Re: Hsiao Short Plat – *Technical Review 1*  
SP22-004

RE: Hsiao Short Plat, File# SP22-004  
Preliminary Short Subdivision of 1.14 acres into five (5) single-family detached lots  
4100 81<sup>st</sup> Place NE & Parcel # 00550600001200, 00550600001300, 30052100314700

PORTION OF NE 1/4 OF SW 1/4 OF SECTION. 21, TOWNSHIP 30N, RANGE 5E, WM

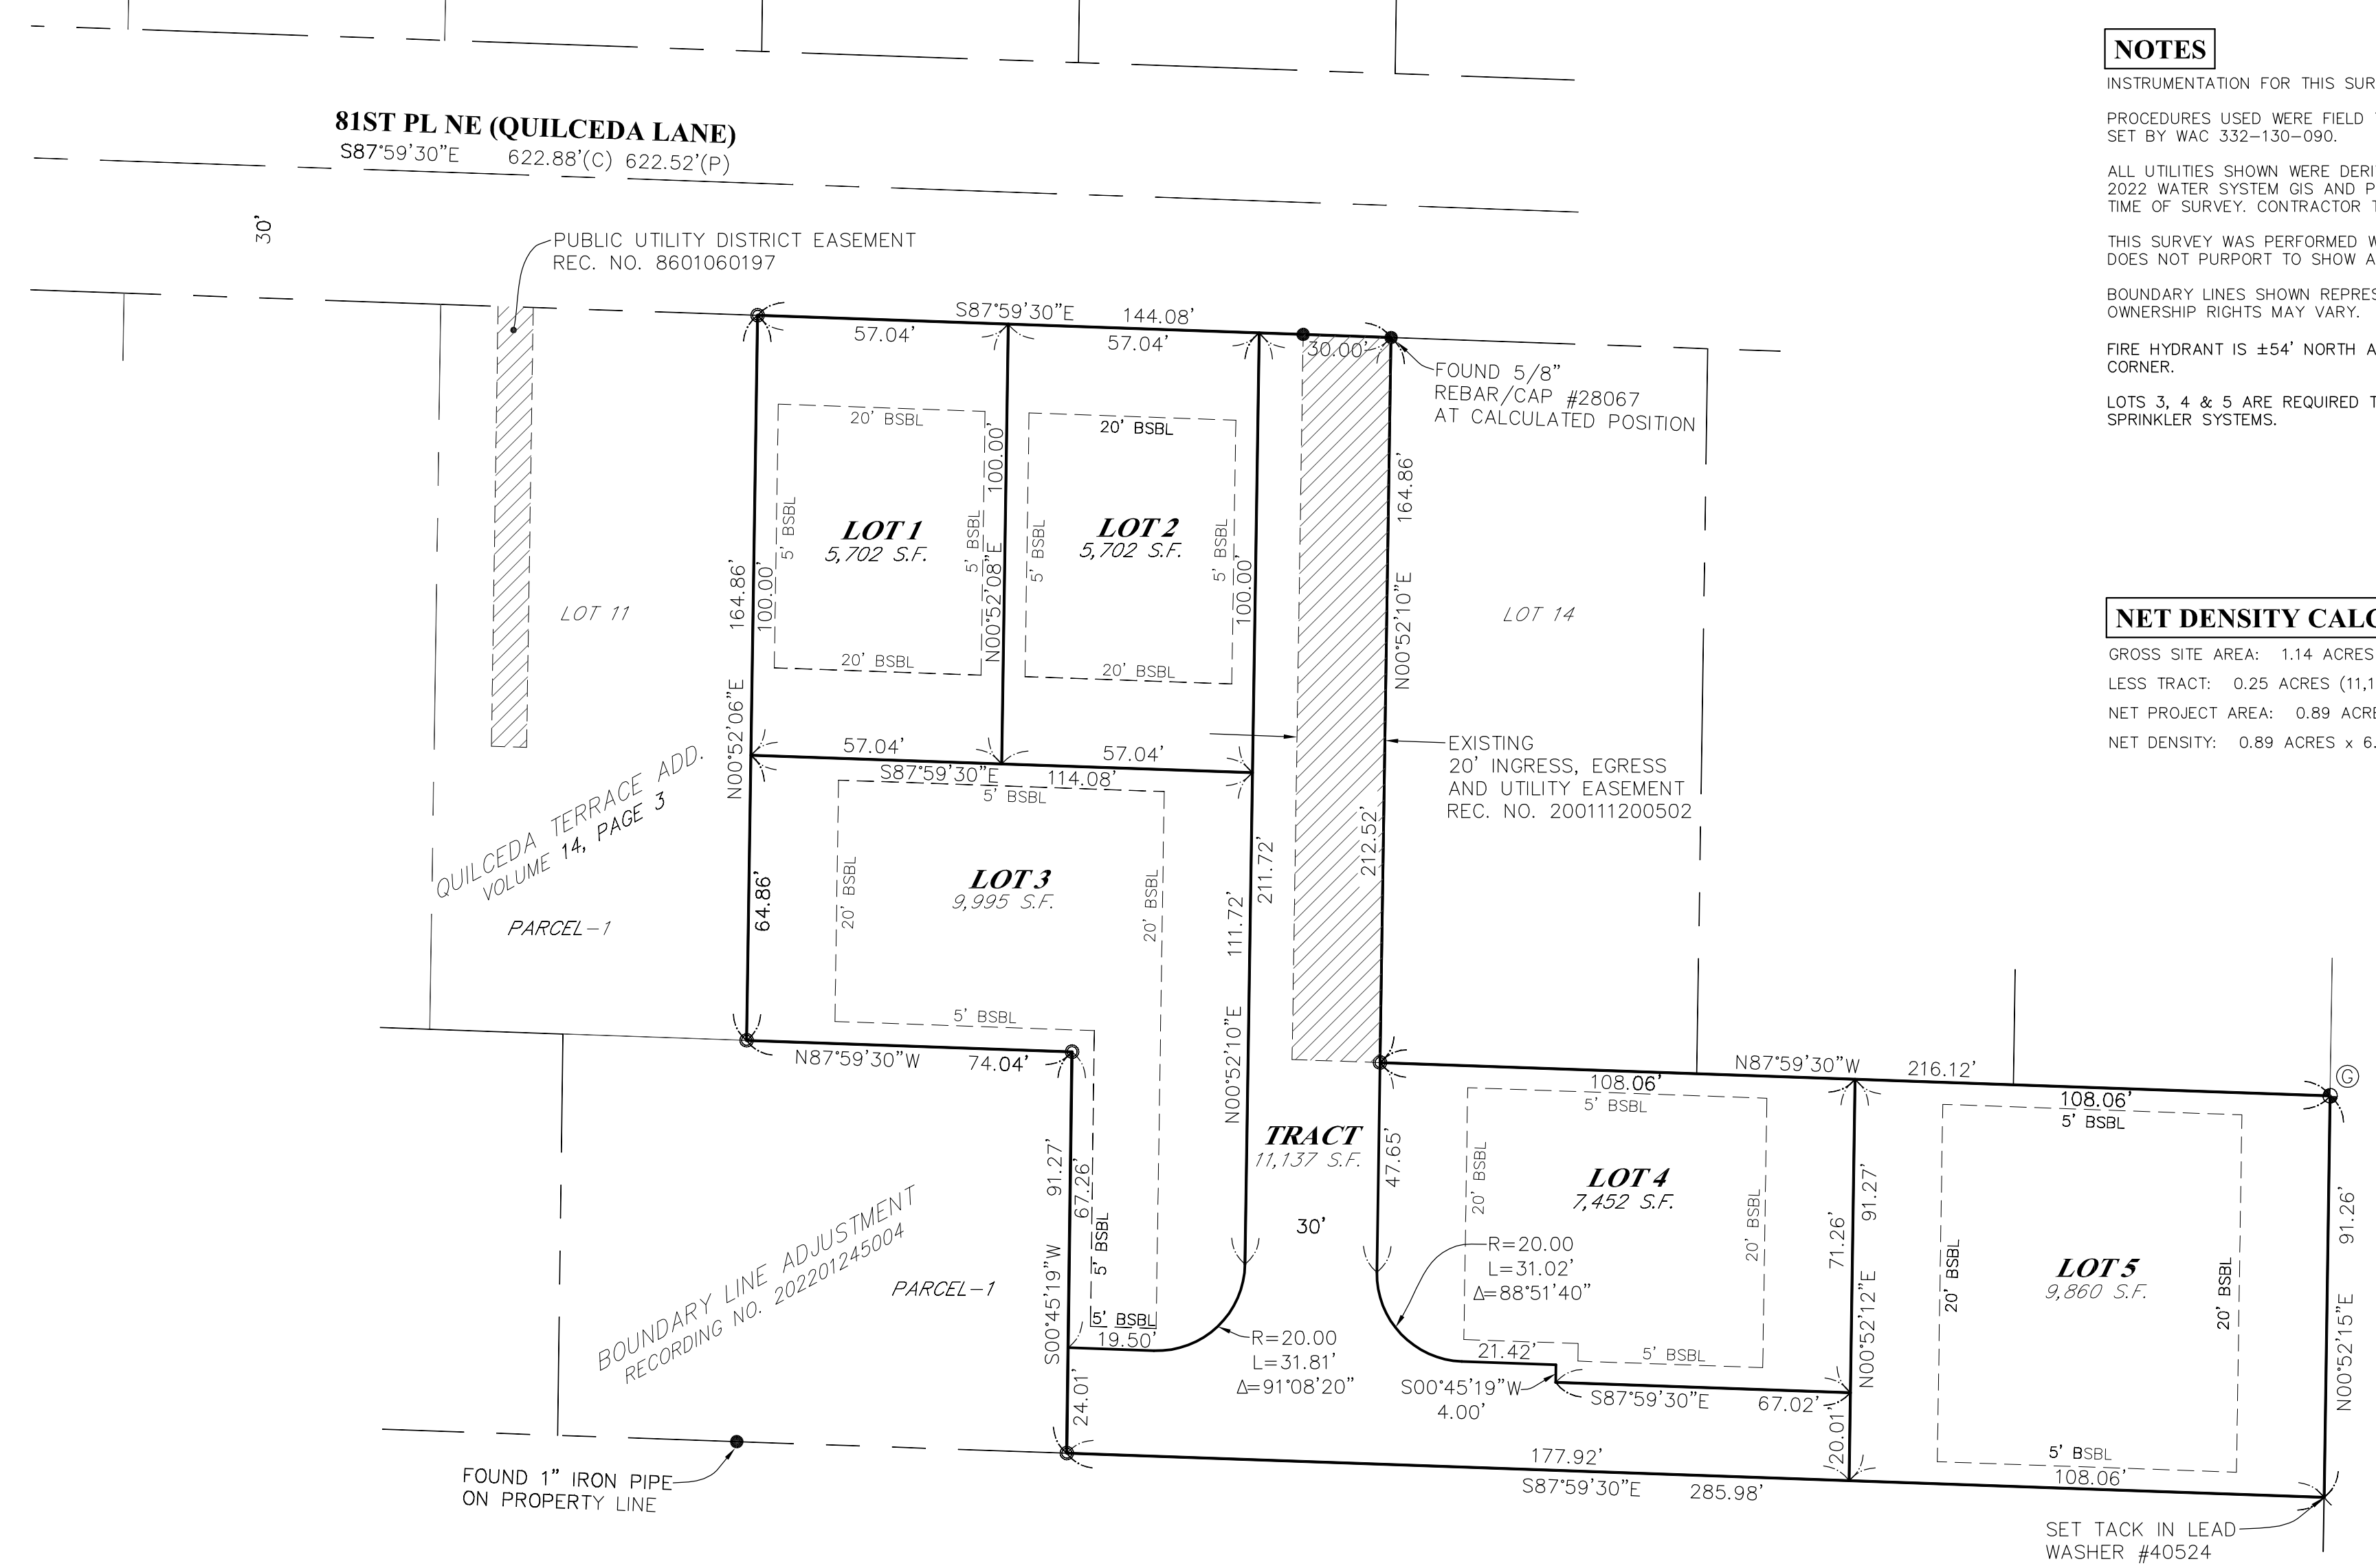
3. The Preliminary Short Plat Map and Preliminary Civil Plans shall be amended as follows:
  - a. The Preliminary Short Plat Map is rather busy. Suggest adding a Sheet 2 to include existing conditions and turning off the existing conditions layers on Sheet 1.

- b. Incorporate the section of Lot 4 to the west of the access tract into Lot 3.
  - c. Separate the access easement into an access tract and amend all Lot SF and provide Tract SF.

- d. Provide new net density calculations after deducting the access tract. Additionally, density allowance shall be shown, as follows:

- e. Remove "LOT SIZE AVERAGING CALCULATIONS."
  - f. Lot and tract lines shall be solid and not dashed.
  - g. The Building Setback Lines (BSBL) for Lots 4 & 5 should be amended so the front and rear setbacks (20') are on the east and west property lines and the side yard setback (5') are on the north and south property lines, similar to Lot 3.

- h. Depict and reference the Auditors File Number (AFN) of the following encumbrance outlined in the Title Report, prepared by Chicago Title Insurance Company:

- PUD Easement recorded under AFN 8601060197; and
  - i. Provide a note that Lots 3, 4 & 5 are required to be constructed with residential fire sprinkler systems. This will be a condition of preliminary SP Approval.
